Consultation Response from: KC Environmental Health (Pollution & Noise Control)		
2021/93270 - Land at, Station Road, Skelmanthorpe, Huddersfield, HD8 9BA		
Discharge of conditions 3 (construction management), 4 (temporary drainage), 5 (temporary waste arrangements), 7 (adoptable roads), 12 (waste storage and collection), 13 (tree protection), 14 (units 23 and 24 revisions), 16 (detailed drainage scheme), 17 (phase II report), 18 (remediation strategy), 23 (materials) and 31 (vegetation removal) of previous permission 2019/91657 for erection of 30 dwellings		
Date Responded: 11 th January 2021	Responding Officer: Natalie Heaney	Responding Ref: WK/202128134
Conditions 4,5,7,12,13,14,16,23 and 31 are outside the remit of Environmental Health Condition 3 – Construction Management Plan To discharge Condition 3, a Construction Management Plan by YCP (Construction) Limited dated 29th November 2021 (Rev A) has been submitted. Our comments relate only to issues within the remit of Environmental Health. These are the hours of works, details of dust suppression measures, details of measures to control noise and vibration from construction-related activities, and details of artificial lightin

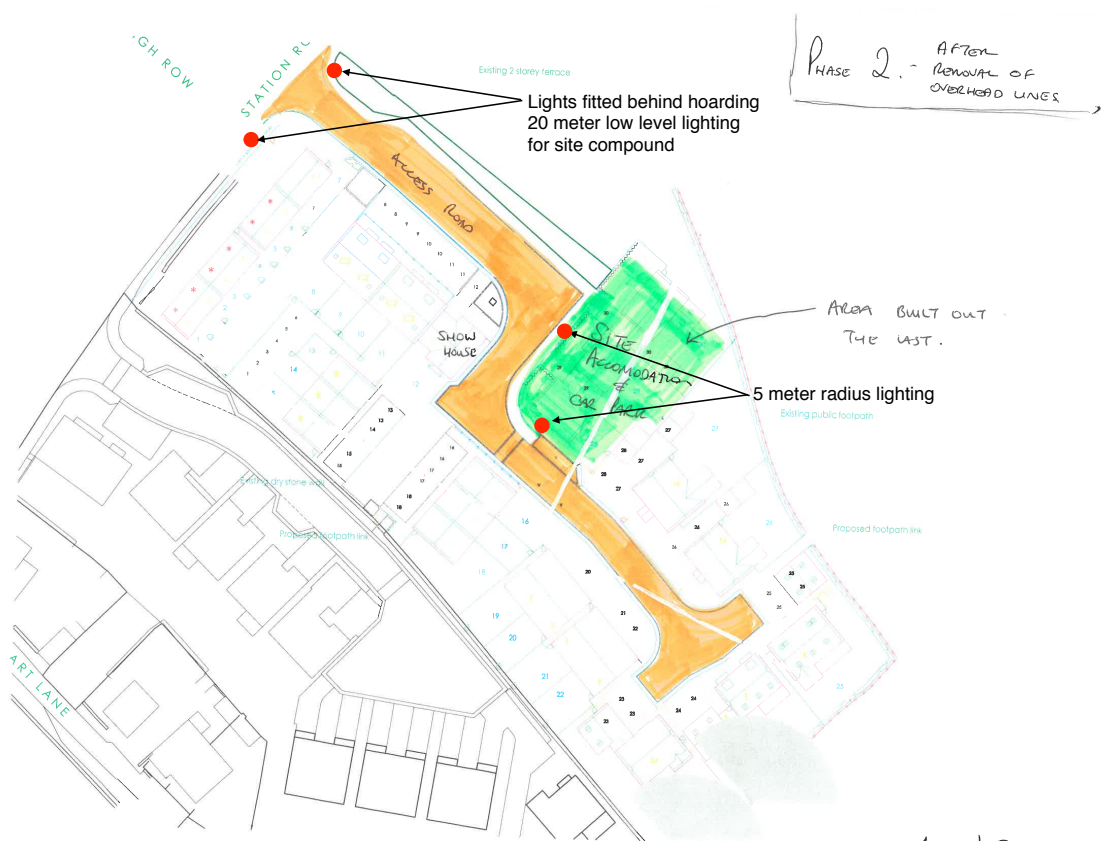
Like the other lights described, these will also be triggered via a motion sensor. A plan detailing the positions of outdoor lighting is also provided.

Having read the report, we consider that the submitted information meets the Environmental Health requirements of Condition 3 and recommend that Condition 3 be discharged. Construction must be undertaken in accordance with the Construction Management Plan by YCP (Construction) Limited dated 29th November 2021 (Rev A).
